CITY OF PORTLAND BUILDING PERMIT

PERMIT ID: 2012-46474

has permission to **Chg the Use 2nd fl, 3000 sfStorage to Zumba Studio**

Job ID: 2012-07-4570-CH OF USE Located At: 390 COMMERCIAL ST CBL: 042- D-002-001

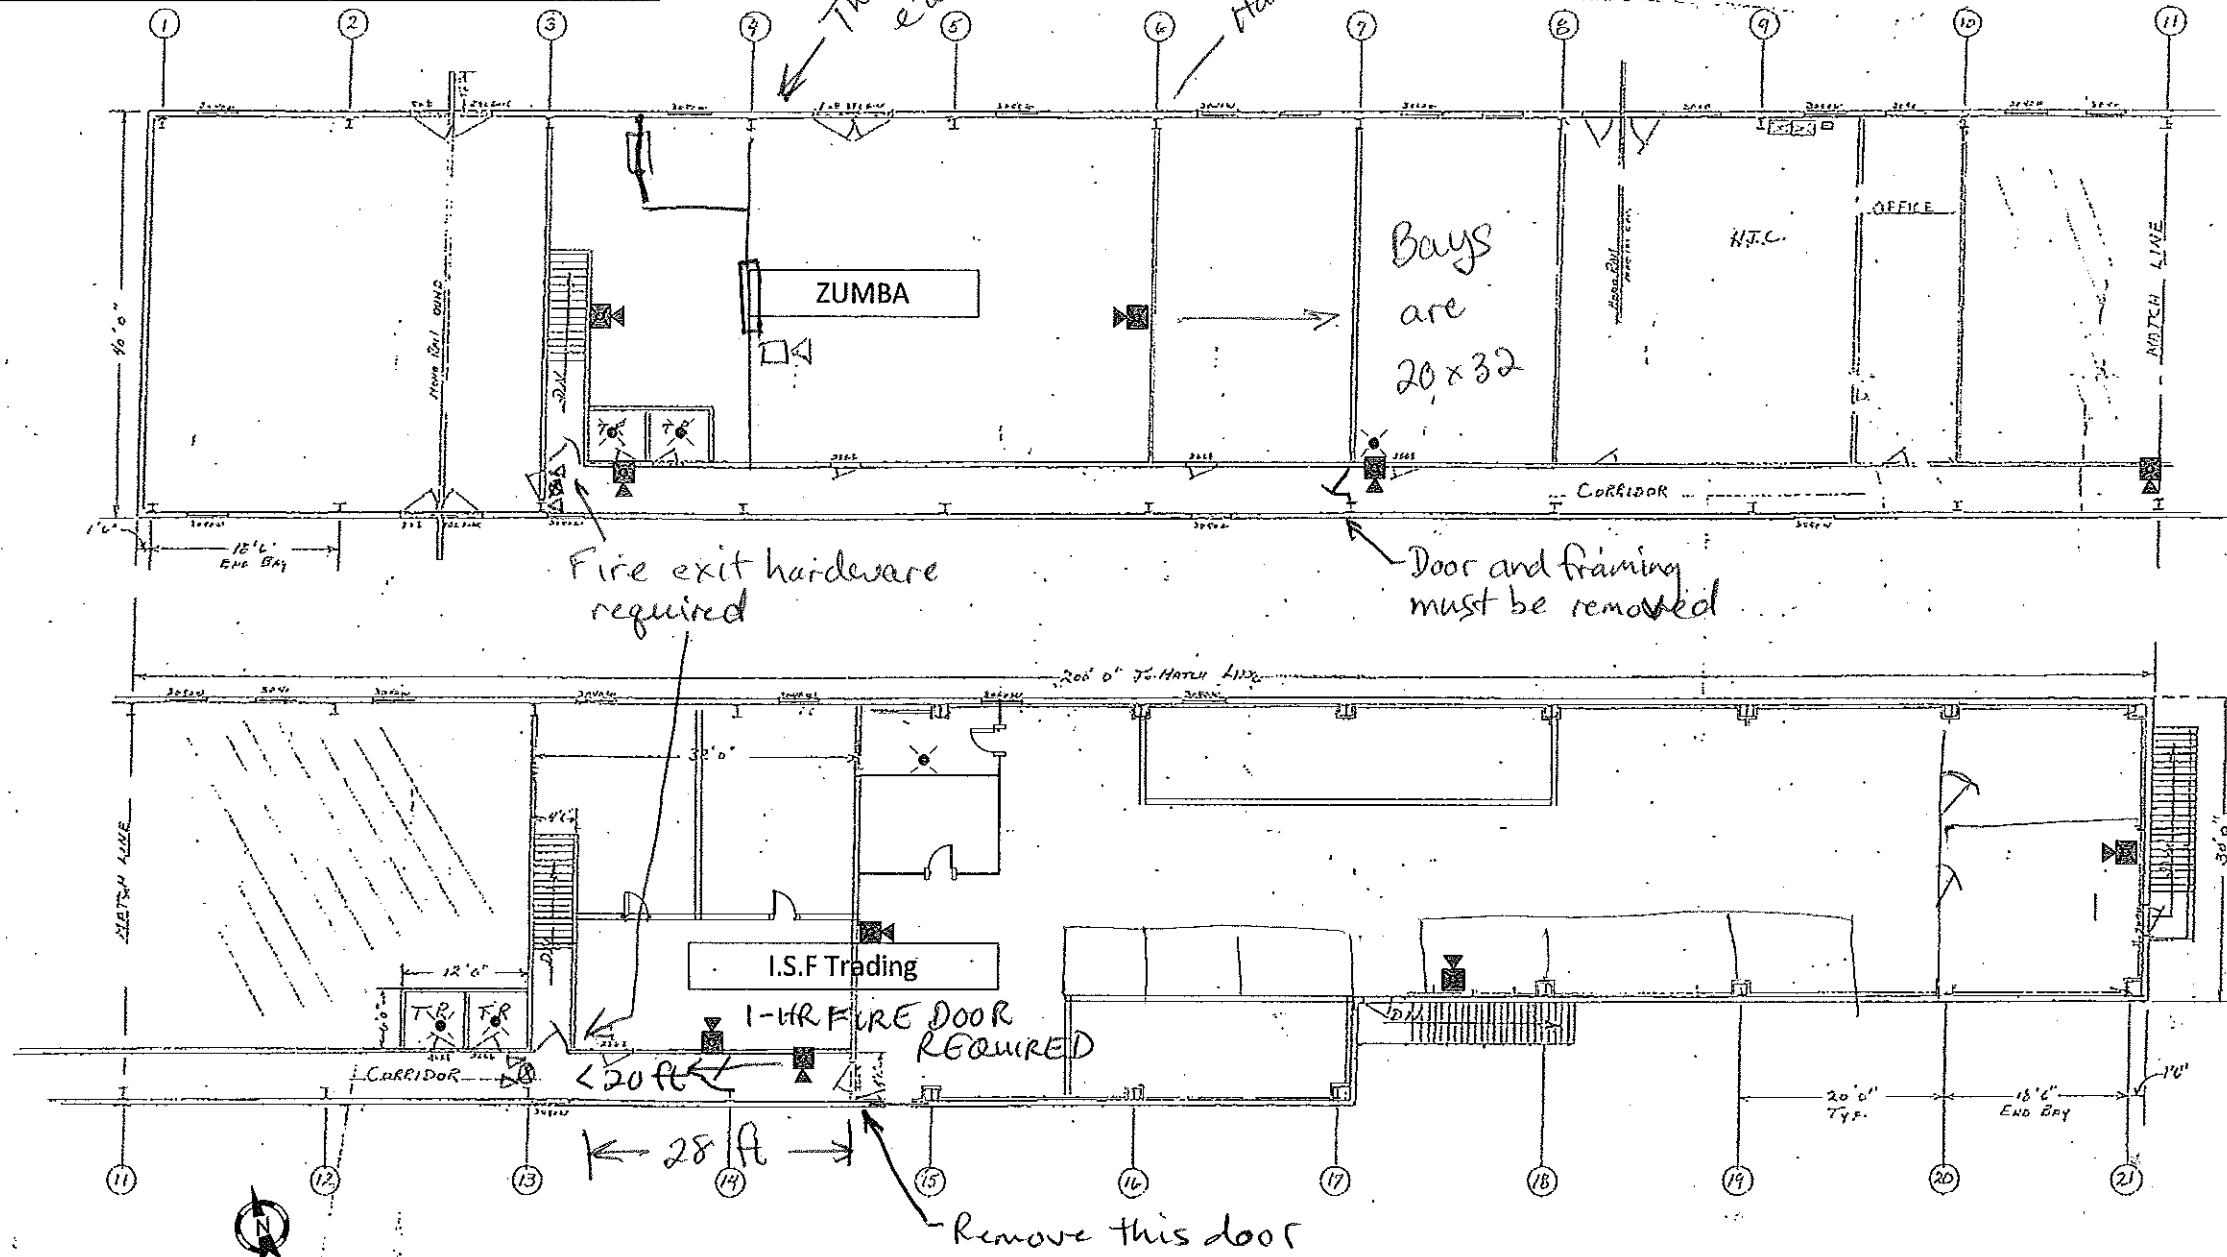
3. The sprinkler system hasn't been inspected in over a year. It requires quarterly inspections. I confirmed there were spaces that had obstructed sprinkler heads and other spaces that lacked sprinklers such as the storage and changing rooms in the Zumba studio space. The owner will be required to have a licensed sprinkler company thoroughly inspect the building and produce a sprinkler inspection and test report and to have the deficiencies fixed.

4. Label the exterior of the outside doors into the two interior stairs. North stair to be labeled STAIR A and the next stair to be STAIR B. Stair A is where the Knox Box and fire alarm panel are to be located.

5. The A and B stairs do not have a fire resistance rating as required. Those stairs must be one-hour fire resistance rated as well as any doors into the stairs. The top and bottom of the stairs have unprotected steel and openings and the B stair has an air conditioner cut into it from an adjacent space.

7. The dead end corridor beyond the B stair exceeds maximum allowances for an assembly use. Maximum dead end allowances for assembly occupancies is 20 feet. He will have to install a 60-minute wall and fire door assembly in a location that reduces the dead end corridor to less than 20 feet and remove the unrated door. The space beyond is not approved for occupancy. The new door will have to have signs that state FIRE DOOR - KEEP CLOSED and NOT AND EXIT visible from the corridor side.

8. The fire alarm system has to be installed and certified. See permit 2012-65617.
9. The cross corridor door and framing on the second floor between the A and B stairs just beyond the studio space will have to be removed.

10. The two doors from the studio space required listed panic hardware. The doors into the top of the A and B stairs require listed fire exit hardware. The stair doors must be labeled for use with fire exit hardware and must self-close and positively latch.

13. The remainder of the EXIT signs and emergency lights for the corridor and stairs must be tested and operational. An additional emergency light is required half way between the A and B stair in the corridor due to the current emergency lights exceeding 150 feet apart.
